CITY OF ALBUQUERQUE

July 8, 2011

**Re: Altura Additional Parking
Grading and Drainage Plan
Engineer's Stamp dated 6-14-11 (H17/D071)**

ALTURA OFFICE BUILDING GRADING & DRAINAGE PLAN

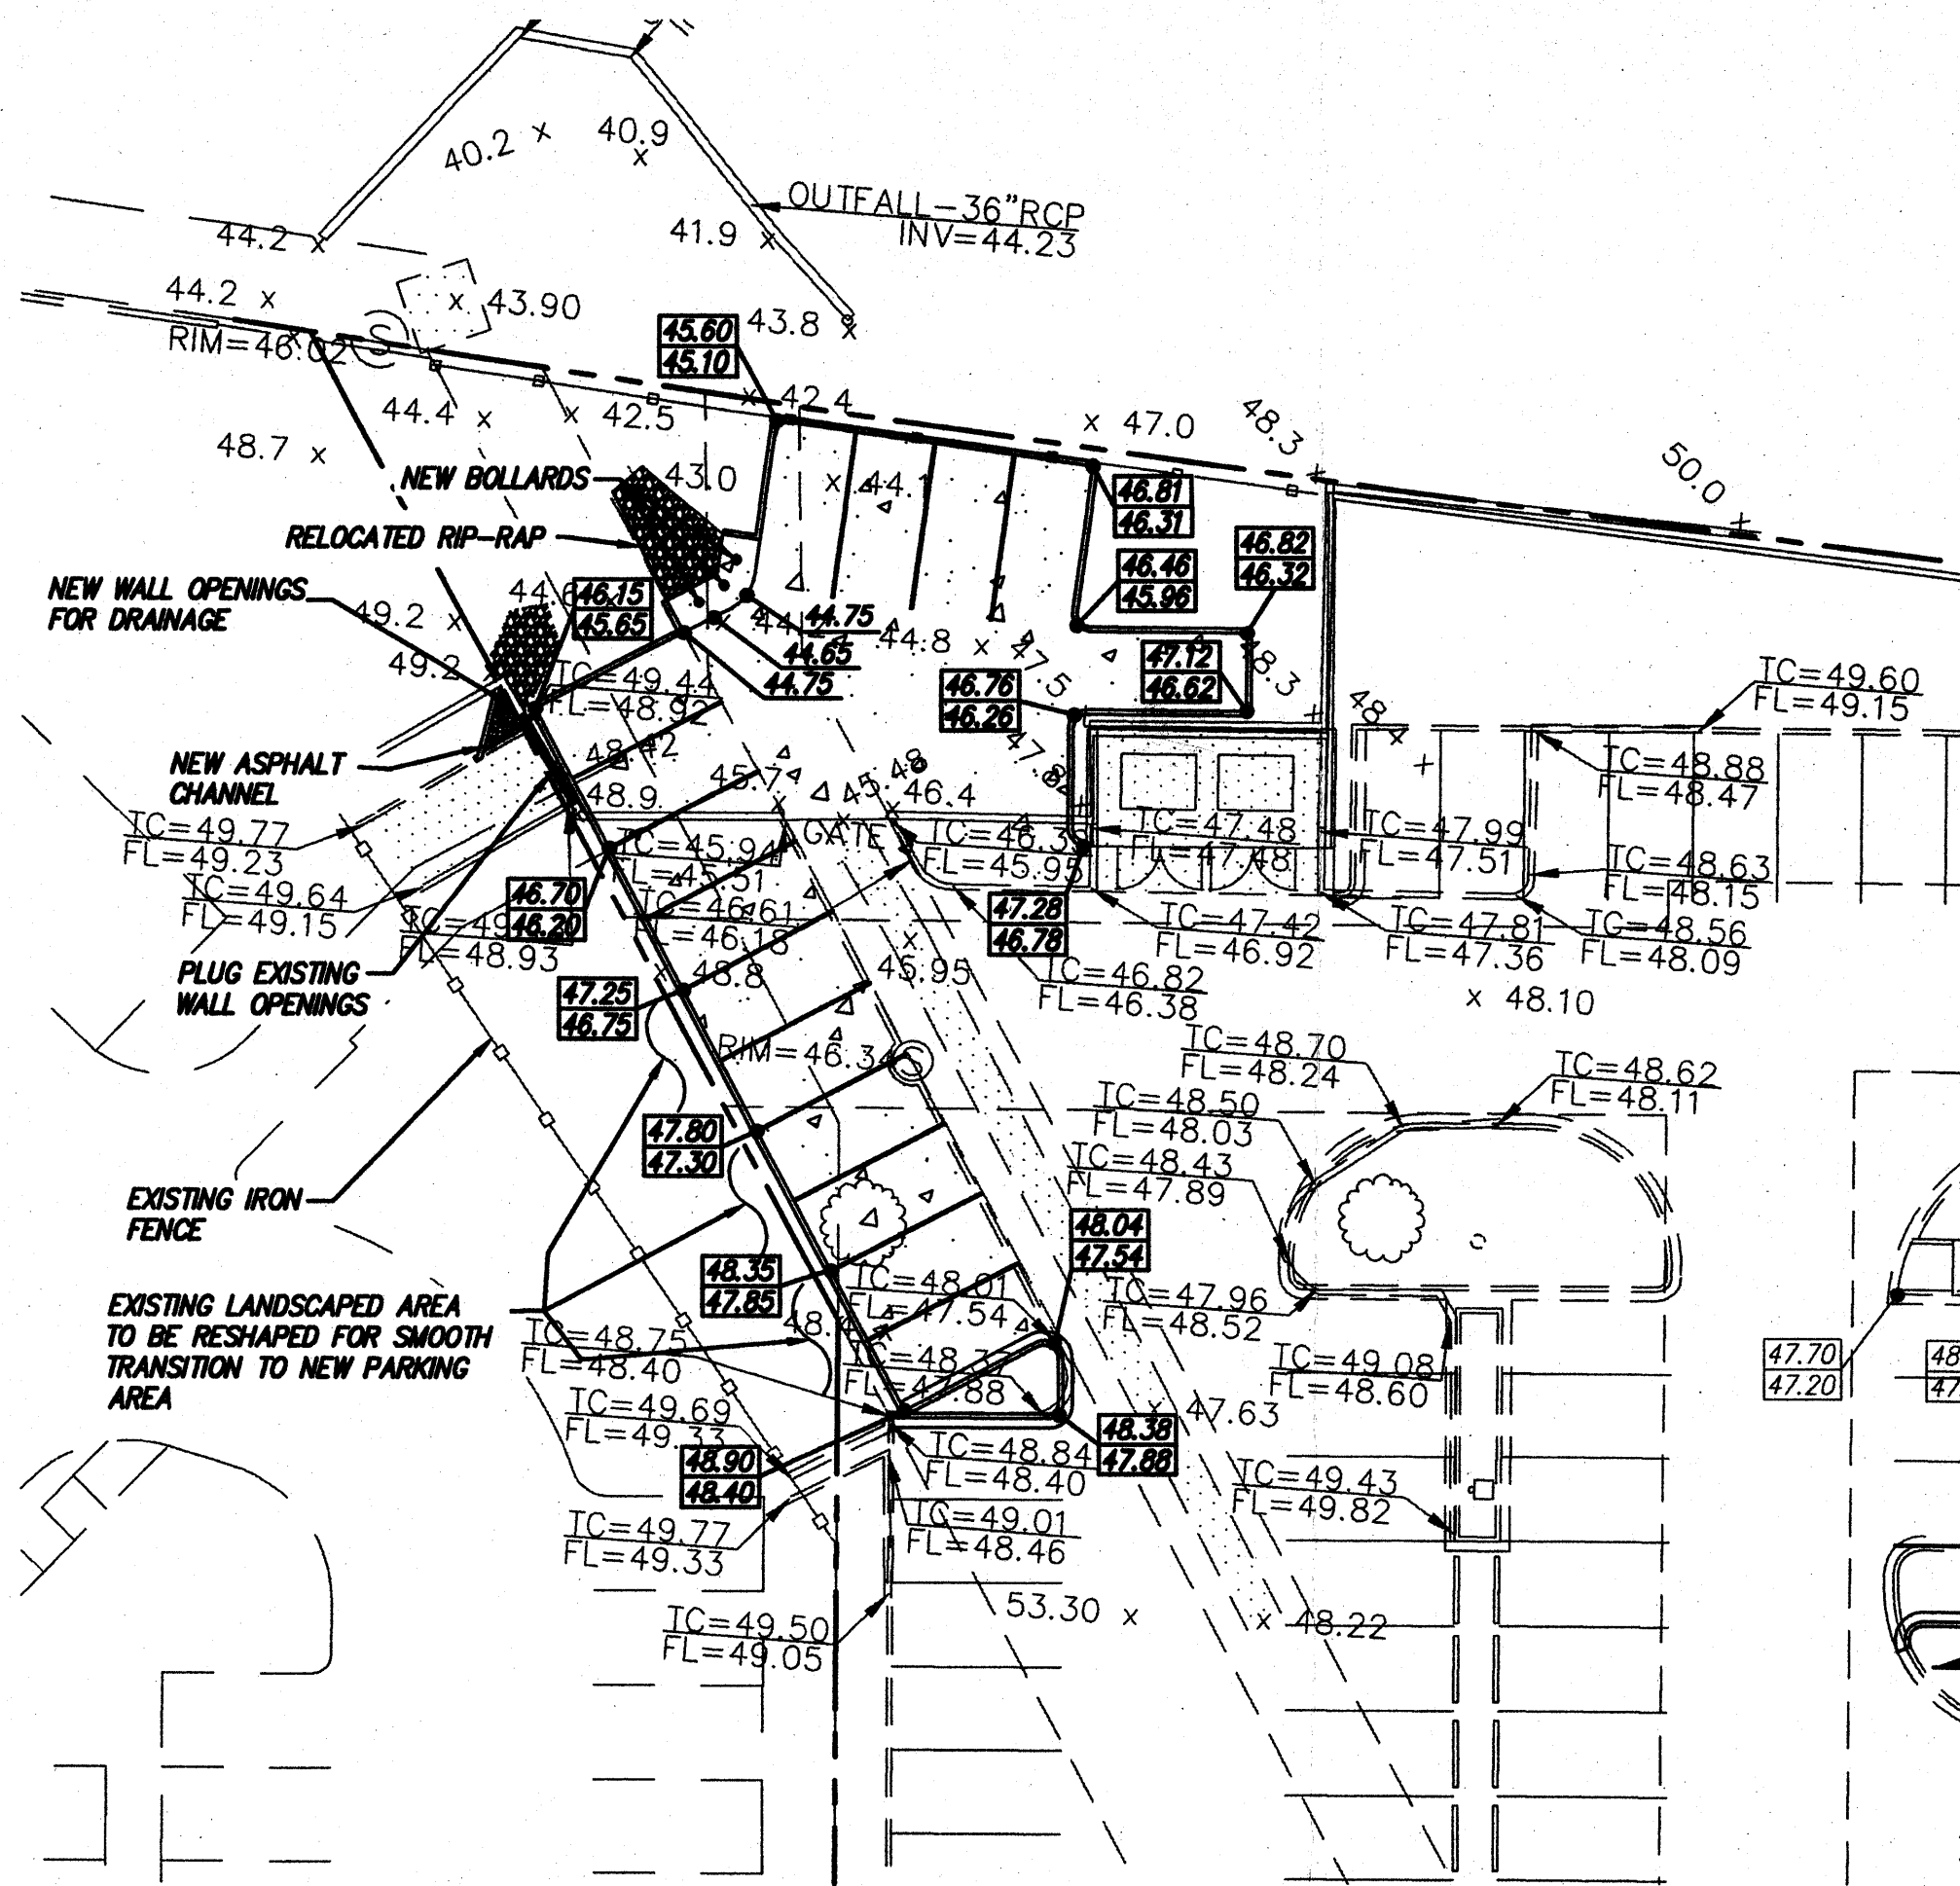
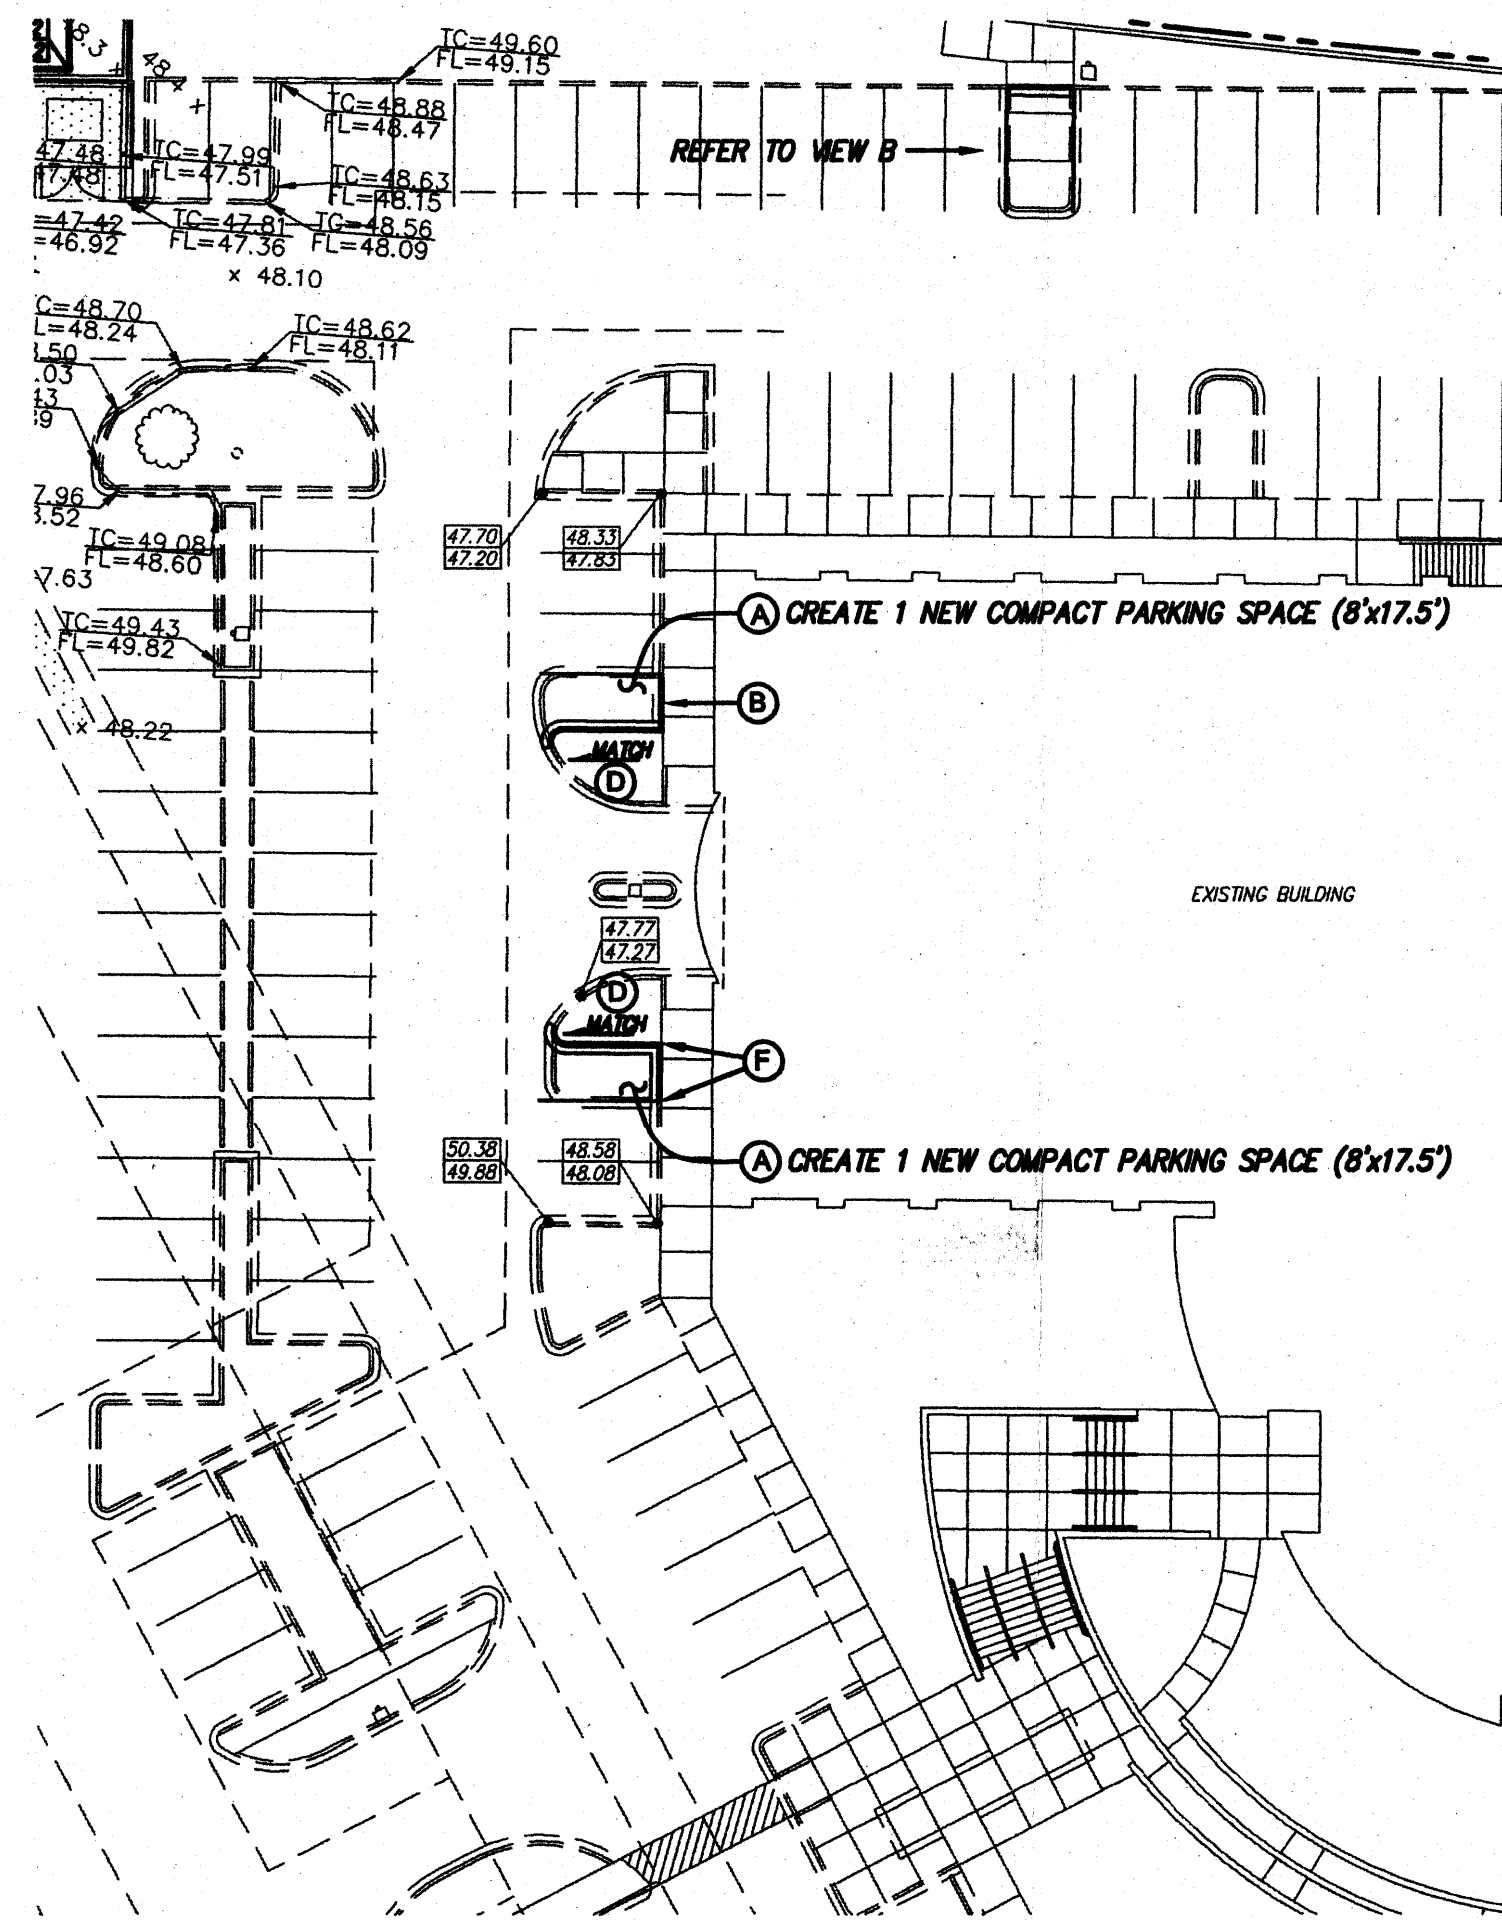
- What are the existing flows and the new flows?
- At this time Hydrology is only reviewing phase 1. Before phase 2 can be reviewed, a vacation of right of way for Indian School Road is needed.

Hydrology is requesting that proposed landscape areas be depressed to retain/infiltrate the rain that falls on them.
